## **APPENDIX 12.7**

## Landscape Response

In respect of a Further Information Request (RFI)

Project Admiral (WCC planning ref. 25/60344)

1. DISTANCE FROM THE ROAD

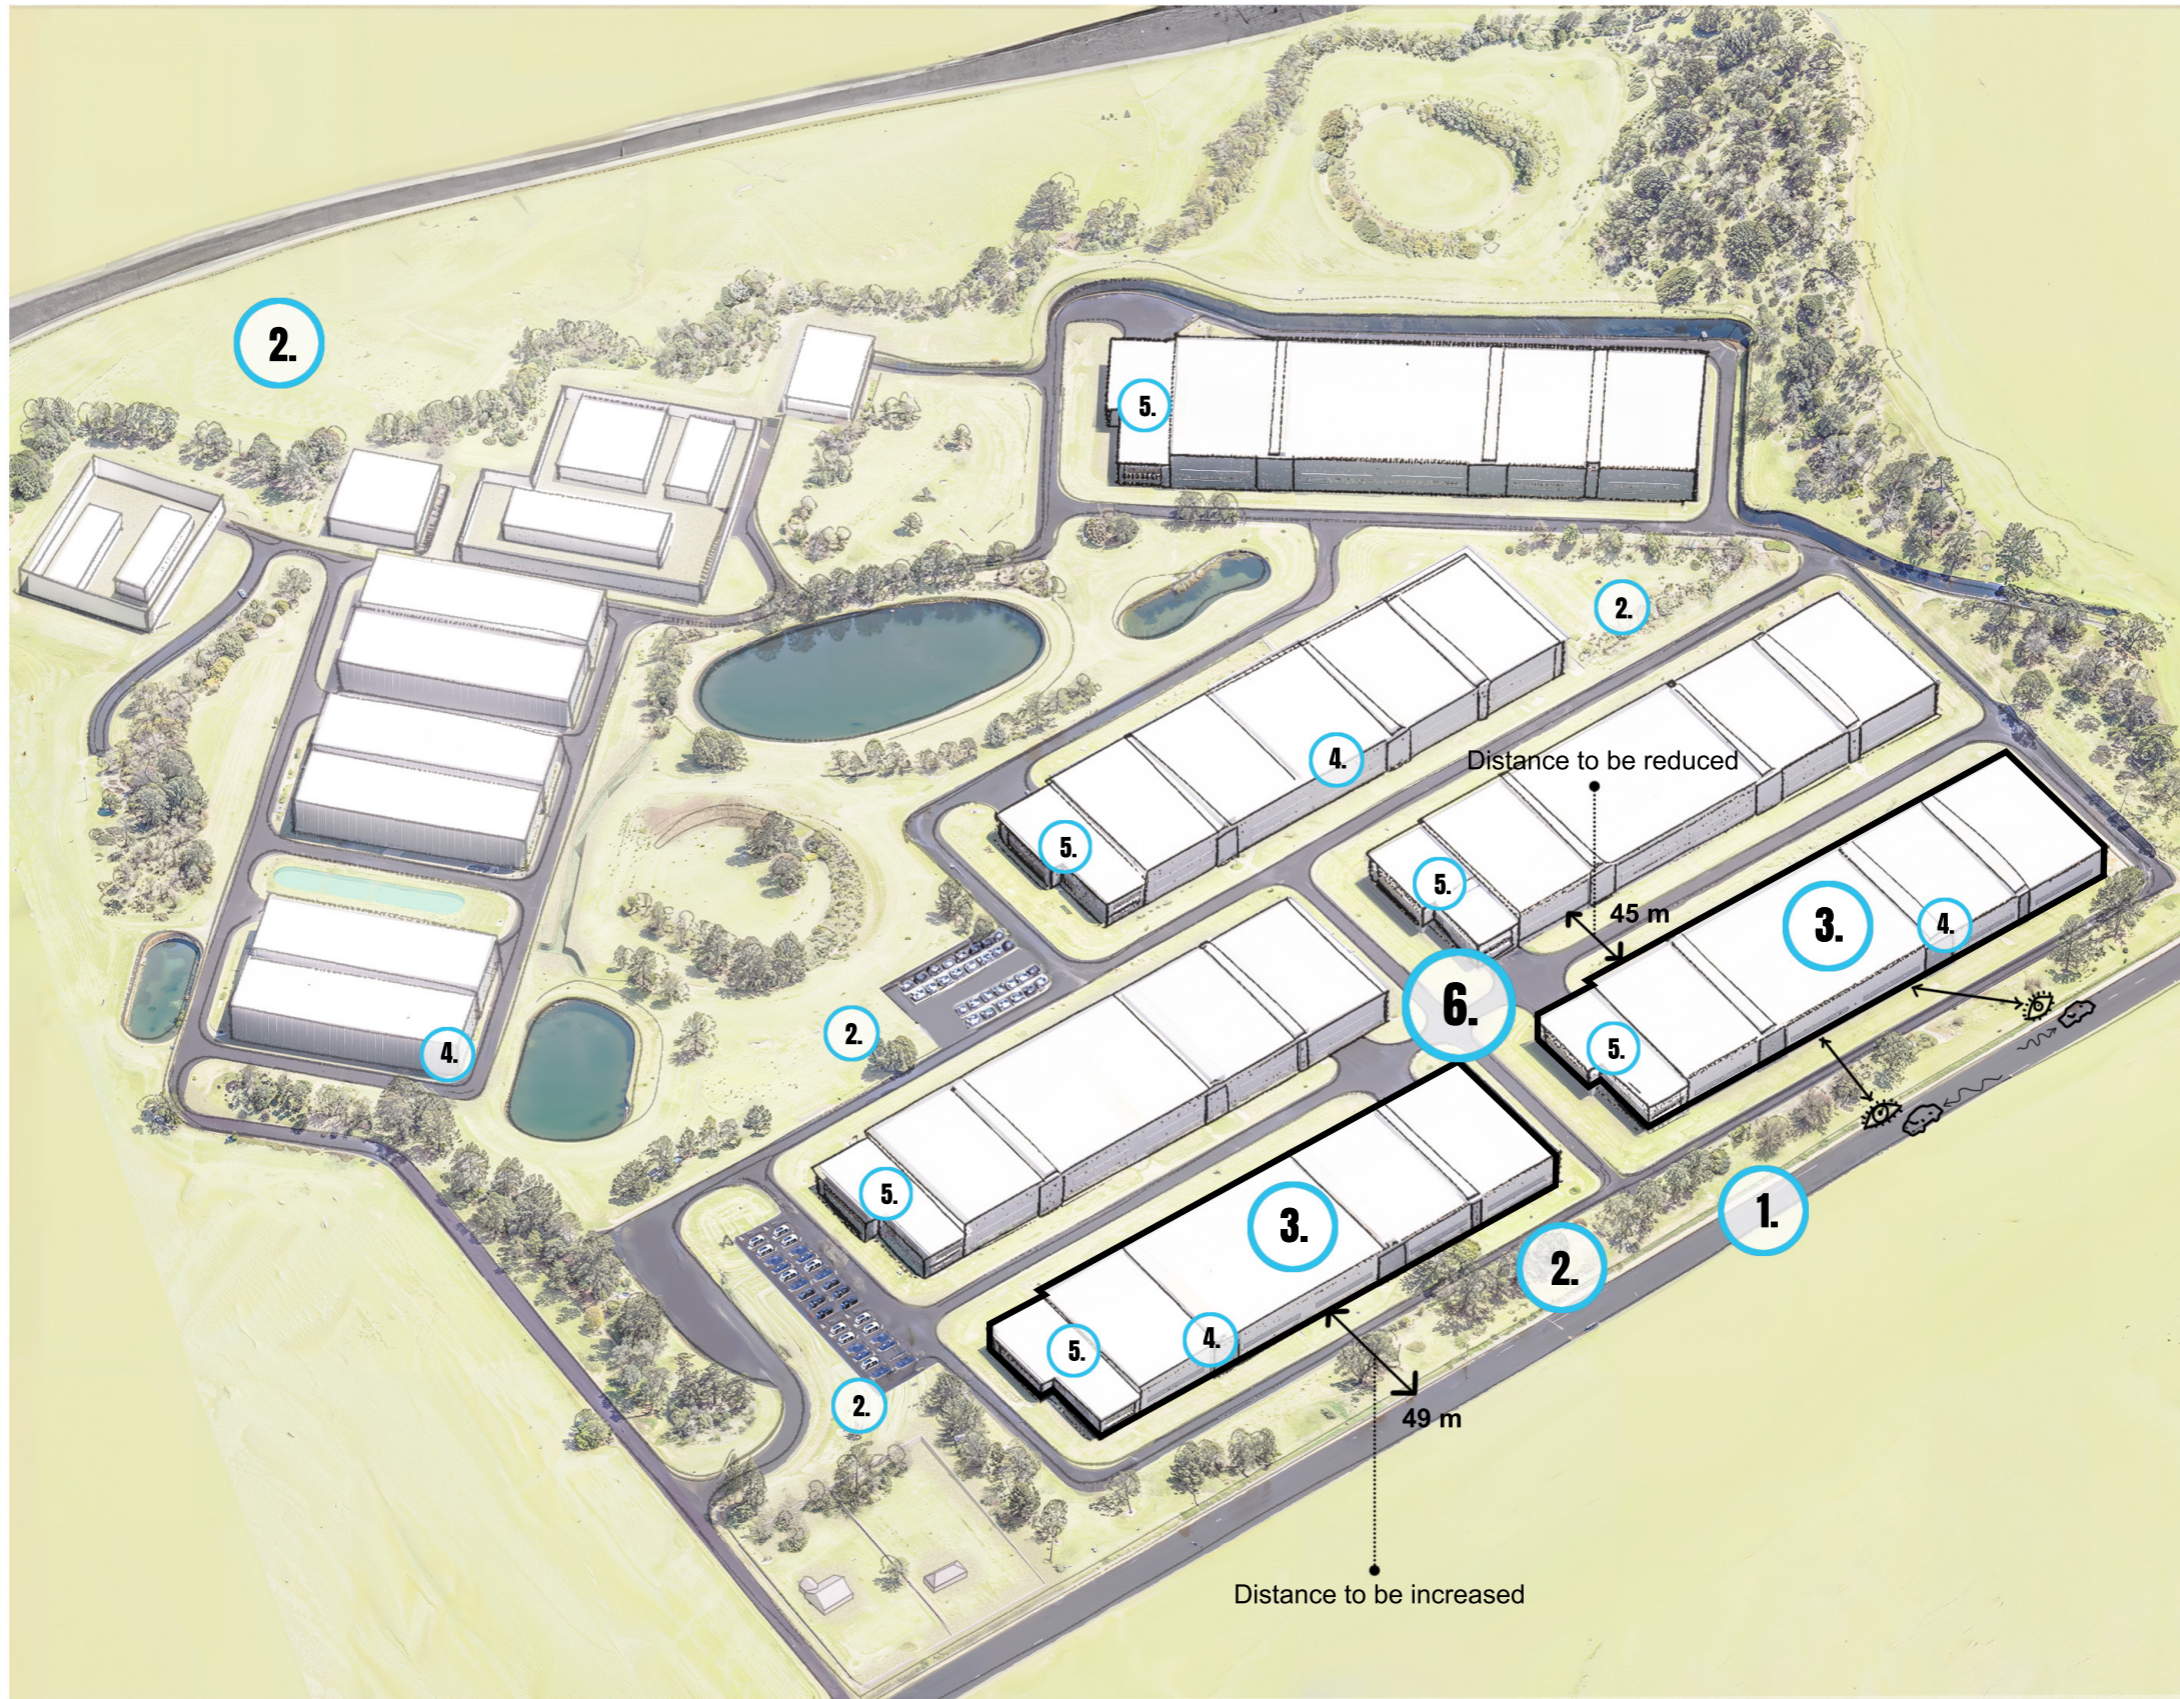
*It is considered that the siting, orientation, and overall layout of the proposed Data Centre buildings would create a visually dominant, industrial-scale frontage along the R344. This would result in a significant adverse impact on the visual character of the surrounding rural landscape. The six buildings are presented as repetitive, industrial-scale structures more typical of a heavy industrial estate, with little or no evident response to the visual sensitivity of the rural setting. The development would benefit from significantly improved architectural quality and stronger design integration to better reflect and respect the surrounding rural landscape context.*

*Site layout plans to be submitted showing a revised configuration of the proposed data centre buildings that allows for clear separation from the regional road and existing roadside dwellings, thereby reducing visual impact and ensuring a more sympathetic relationship with the rural setting*

It should be noted that, as part of the design amendments introduced during the Further Information stage, additional mitigation measures have been incorporated to further reduce residual visual effects on surrounding local receptors, as outlined in the preceding sections. In particular, the proposed Data Halls have been set back further from the regional road corridor and will now be located approximately 69–71 metres from the roadside hedgerow, generally located at a lower ground level than the regional road. This increased setback will reduce their visual prominence when viewed from the road corridor and associated local receptors. Furthermore, the nearest Data Hall will be positioned approximately 51 metres from the curtilage of the two single-storey dwellings located to the north of the Data Hall component of the development, with the dwellings themselves situated a further distance to the northeast. This spatial separation, combined with intervening vegetation and proposed mitigation planting, will assist in limiting potential visual effects at these residential receptors. In addition, earthen berms are proposed along the northern, western, and north-eastern boundaries of the Data Hall area. These berms will be planted with native woodland species to provide enhanced screening and to assist in visually integrating the development into the receiving local landscape. This measure will further soften the built form and contribute to a reduction in residual visual effects at the nearest surrounding receptors.

FACADE TREATMENT

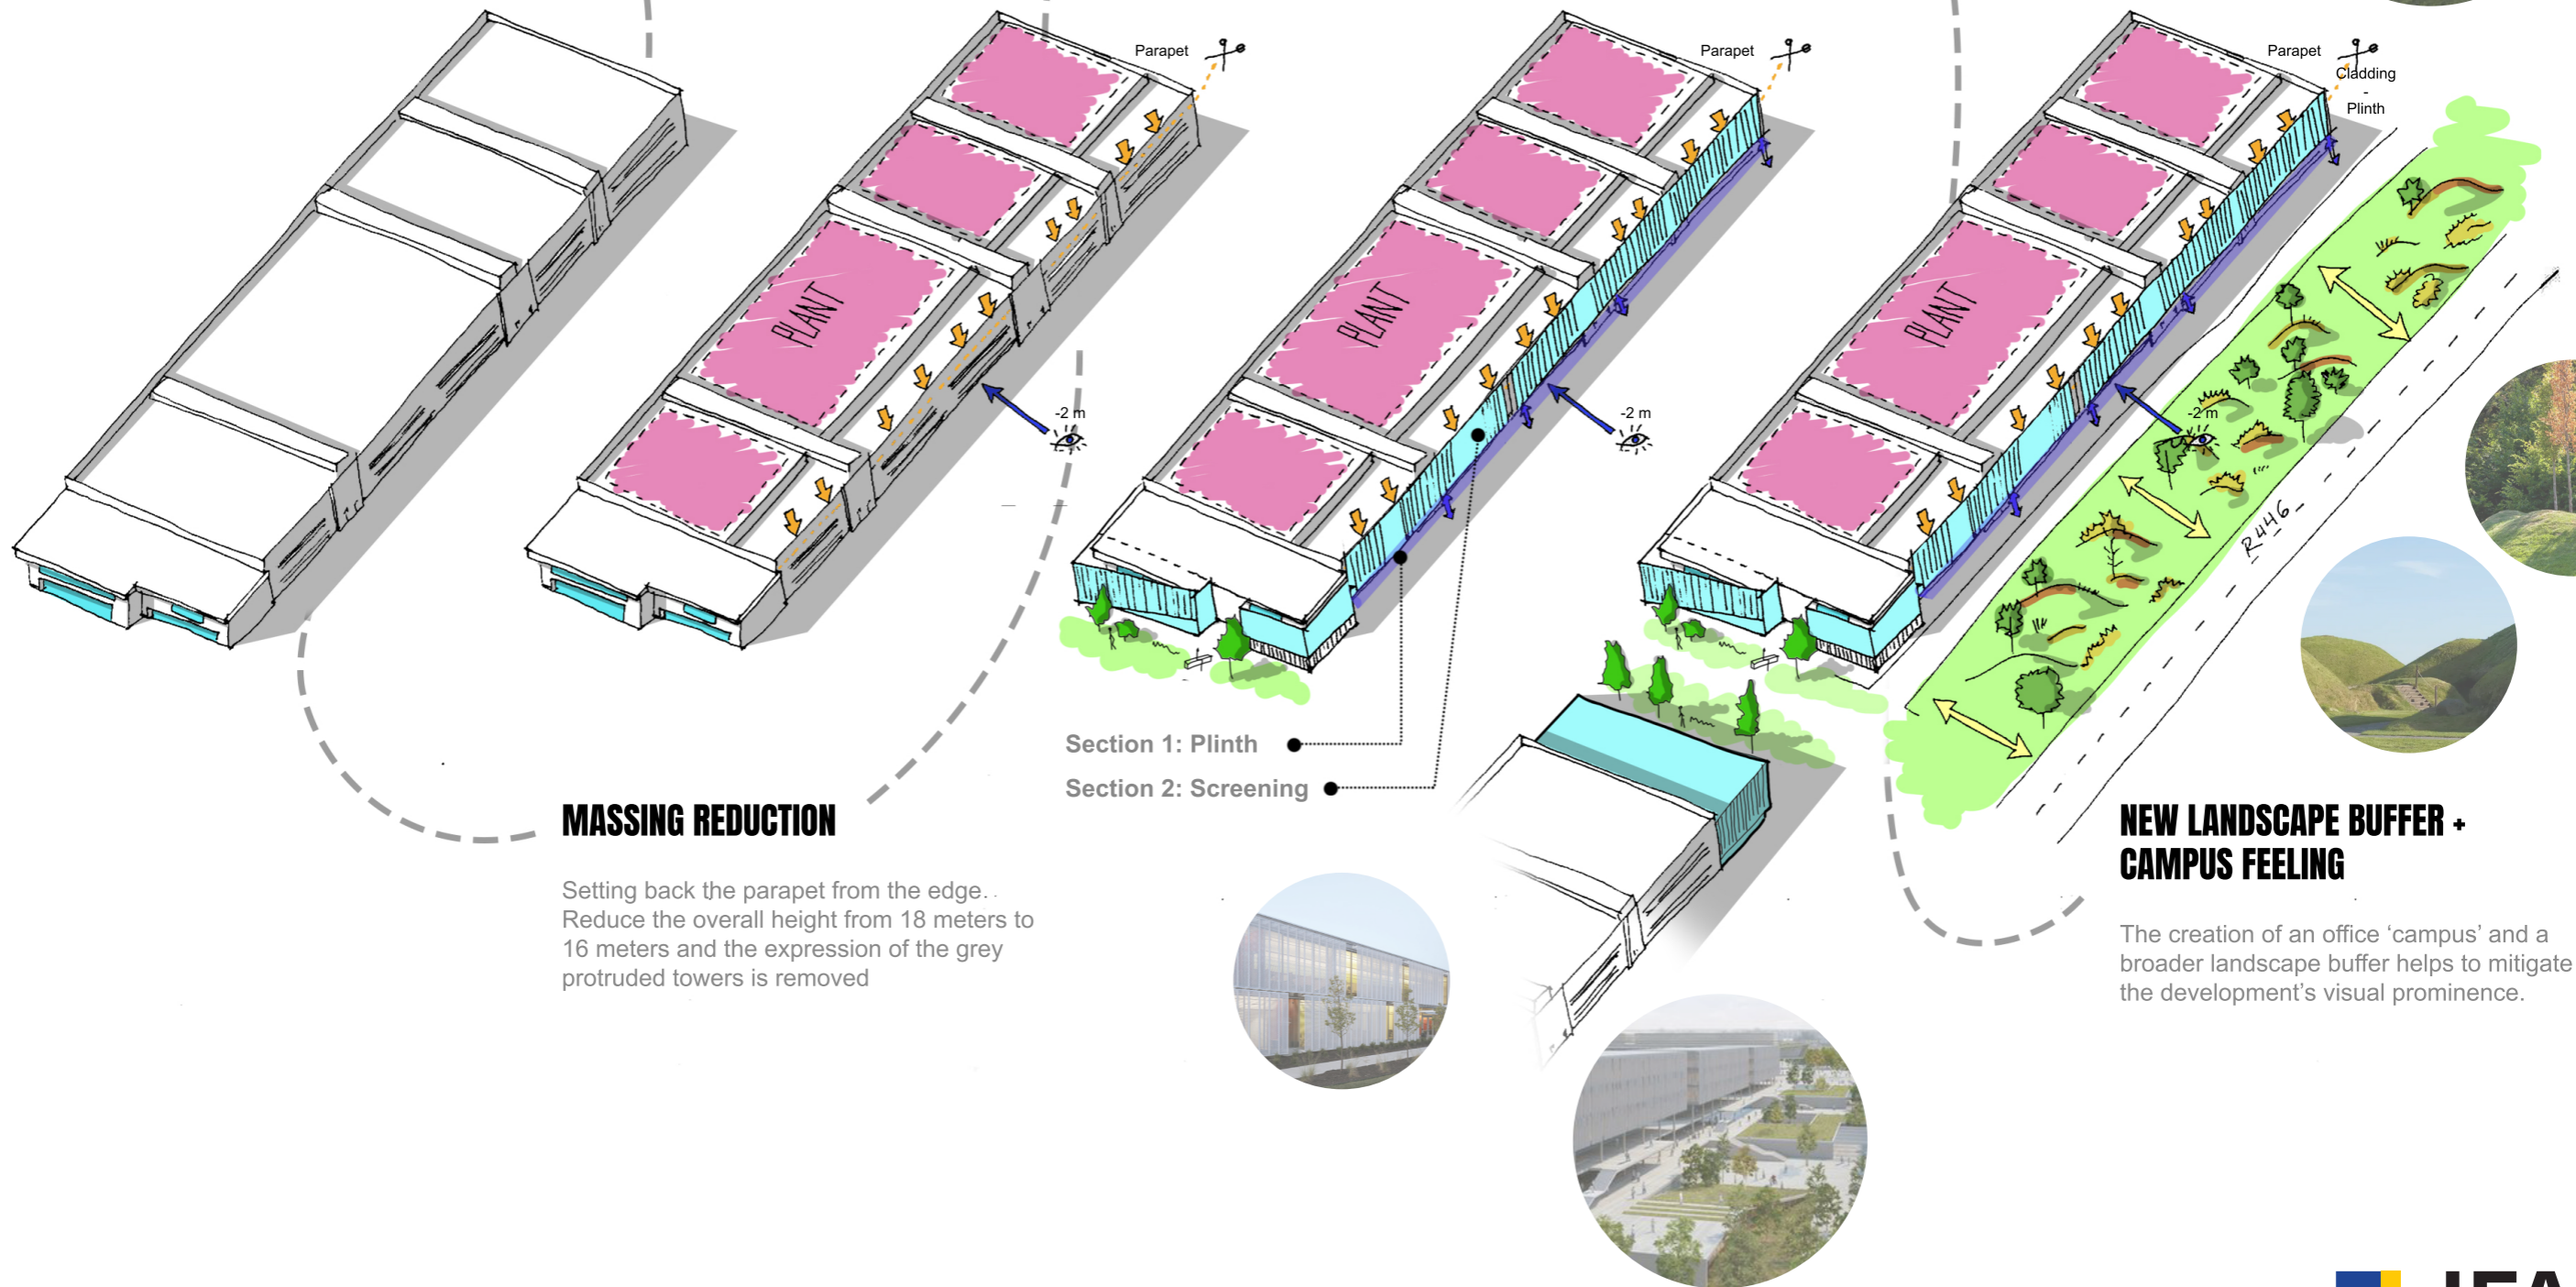
- A. A comprehensive Design Statement outlining the design rationale, architectural intent, and detailing proposed materials and finishes*
- B. Enhanced landscape proposals, including mitigation measures and cross-sections showing how the development will be screened over time*

As set out in the Architectural Design Statement submitted as part of this further information response, amendments to the proposed development have been undertaken during the further information stage, including a comprehensive redesign of the proposed Data Halls. The revised design incorporates a new geometric metal veil along the elevation facing the R446. This metal veil will be mounted approximately 4 m above ground level and set approximately 1 m below roof level. The purpose of this intervention is to diminish the perceived height and scale of the buildings when viewed from the R446 regional road. The angled geometry of the metal veil will further break up the visual mass of the elevations. The varying angles will create changing tones and shadow effects throughout the day as sunlight interacts with the façade, thereby introducing visual depth and texture to the building form. In addition, the proposed Data Halls have been reoriented to create a centralised plaza space where the office elements within each hall converge. These office components will be clad in a mix of glazing and timber battens, introducing variation in materiality, texture, and tone. These interventions will further subdivide the overall building mass and reduce the perceived extent and scale of the Data Halls, particularly in views from the R446.

**Figure 4: Proposed metal veil on the R446 facing side of the proposed data halls**
